Our reference: ECM Ref: 9806967  
Contact: Kathryn Saunders  
Telephone: (02) 4732 8567

29 November 2021

**Request for Advice - Kemps Creek Estate – MOD 2 - SSD-9522 - Estate Roads at No. 657 Mamre Road Kemps Creek**

Figure 1: Site Plan

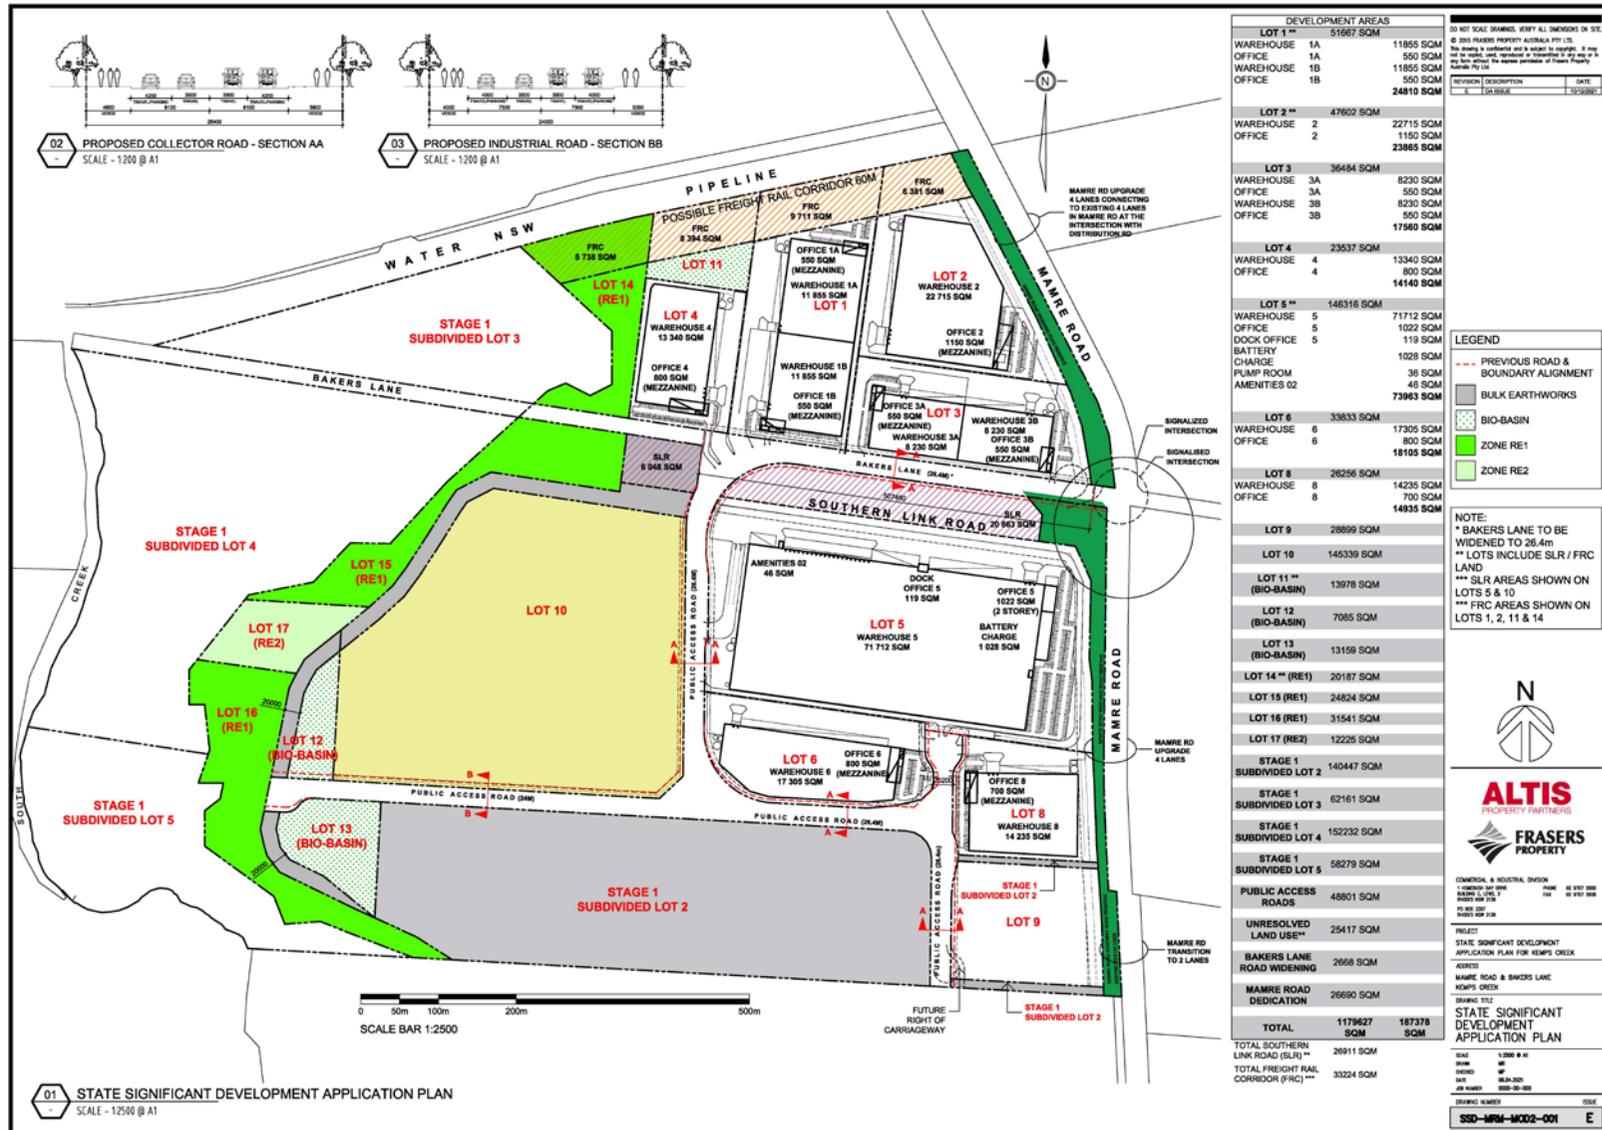
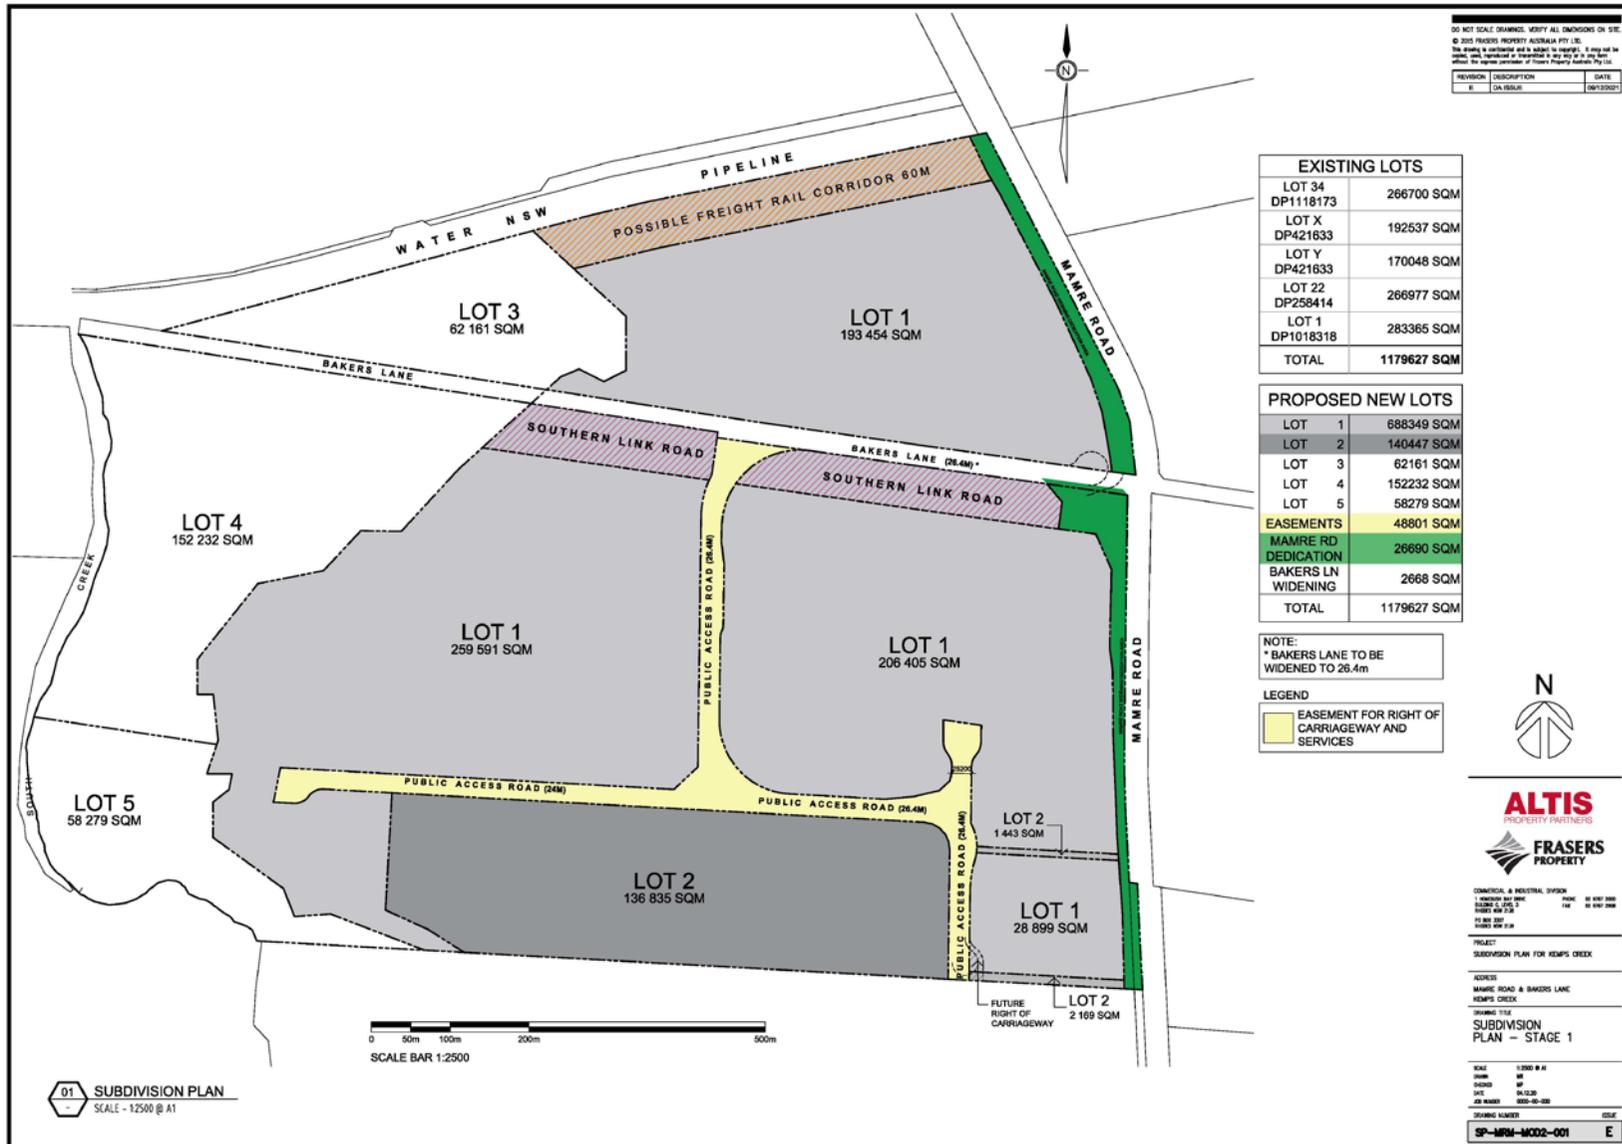
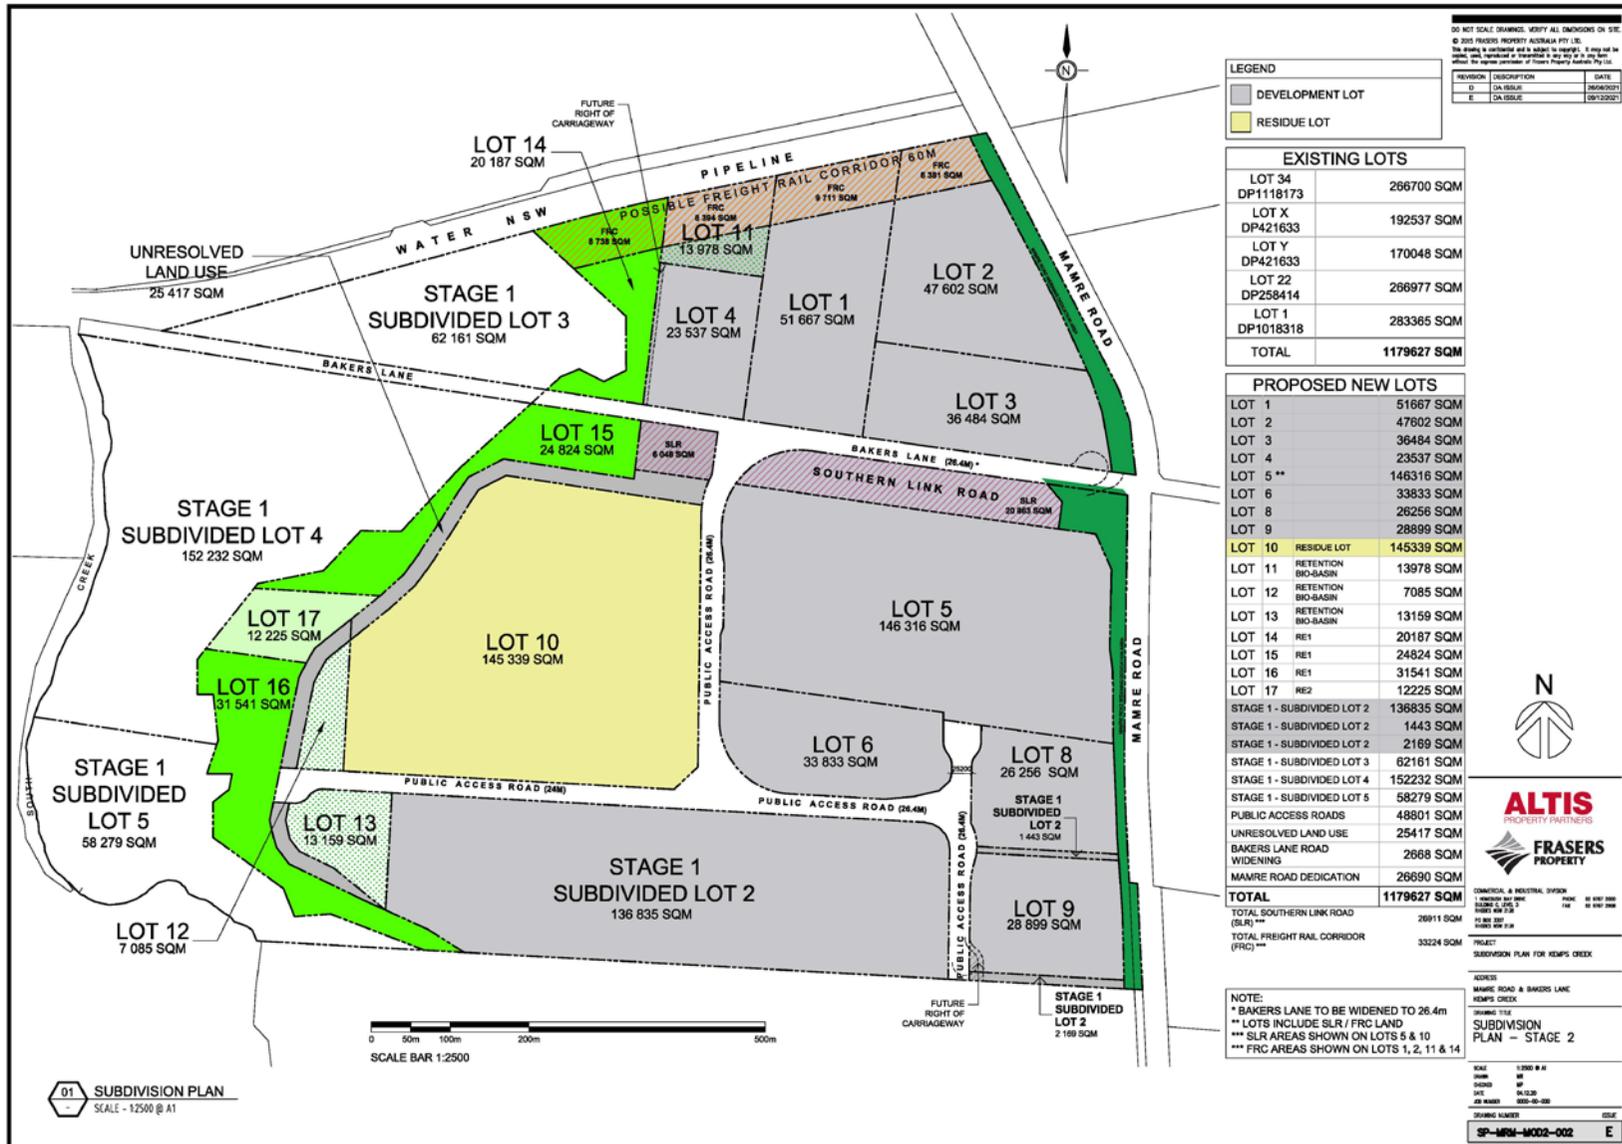
Plans (including bulk earthworks, architectural and landscape and subdivision plans) shall clearly identify the Open Space Edge Road compliant with the location and design requirements and objectives specified within the Mamre Road Precinct DCP. The Open Space Edge Road shall not be nominated as 'Unresolved land use' on plans, sections or details (also refer to engineering comments below).

The width of the Open Space Edge Road shall be consistent through Lot 13 and the Lot nominated as Stage 1, Subdivided Lot 2.

02 PROPOSED DISTRIBUTOR ROAD - SECTION AA
SCALE - 1:200 @ A1

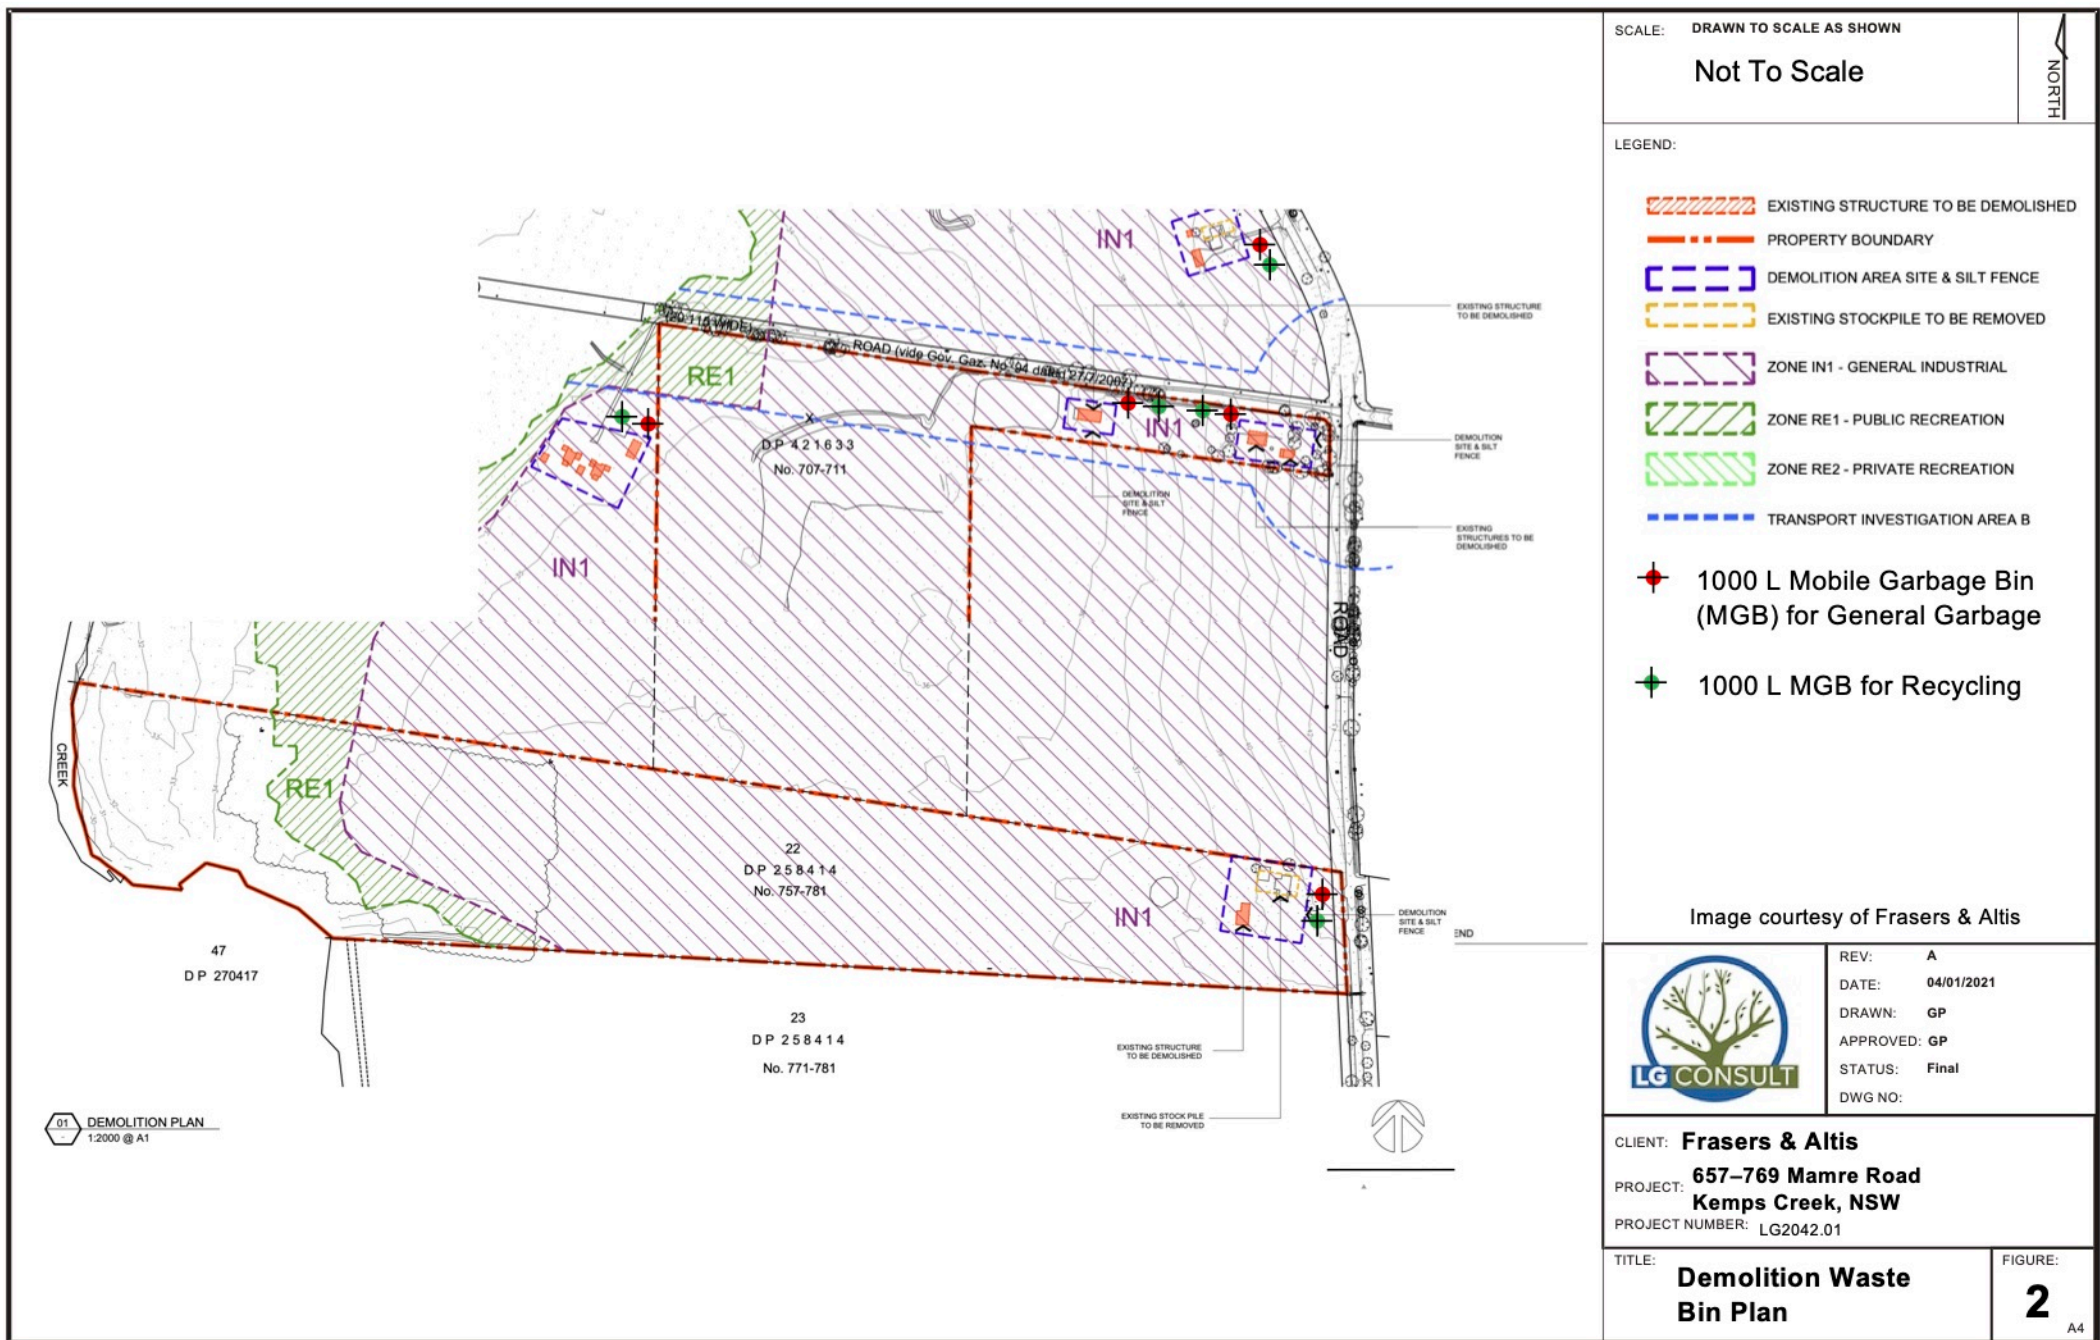
Noting Council's strong objection to the deletion of the central median planting, should DPIE support the reduction of widths resulting in deletion or amendment to central medians, it is recommended that an absolute minimum 1.2m wide

central median (minimum width to shelter a small sign - Austroads Guide to Road Design Part 4A) be provided at the following locations:

- Along the full length of Bakers Lane extending from the intersection with Mamre into the North-South Collector Road to approximately Ch 620. The median is required to prevent right turn access into Lots 1-4.
- Along the North-South Collector Road at the intersection of Access Road 1 and Access Road 3 (tangent point to tangent point).
- Along the North-South Collector Road at the intersection of Access Road 1 and Access Road 2 (tangent point to tangent point).
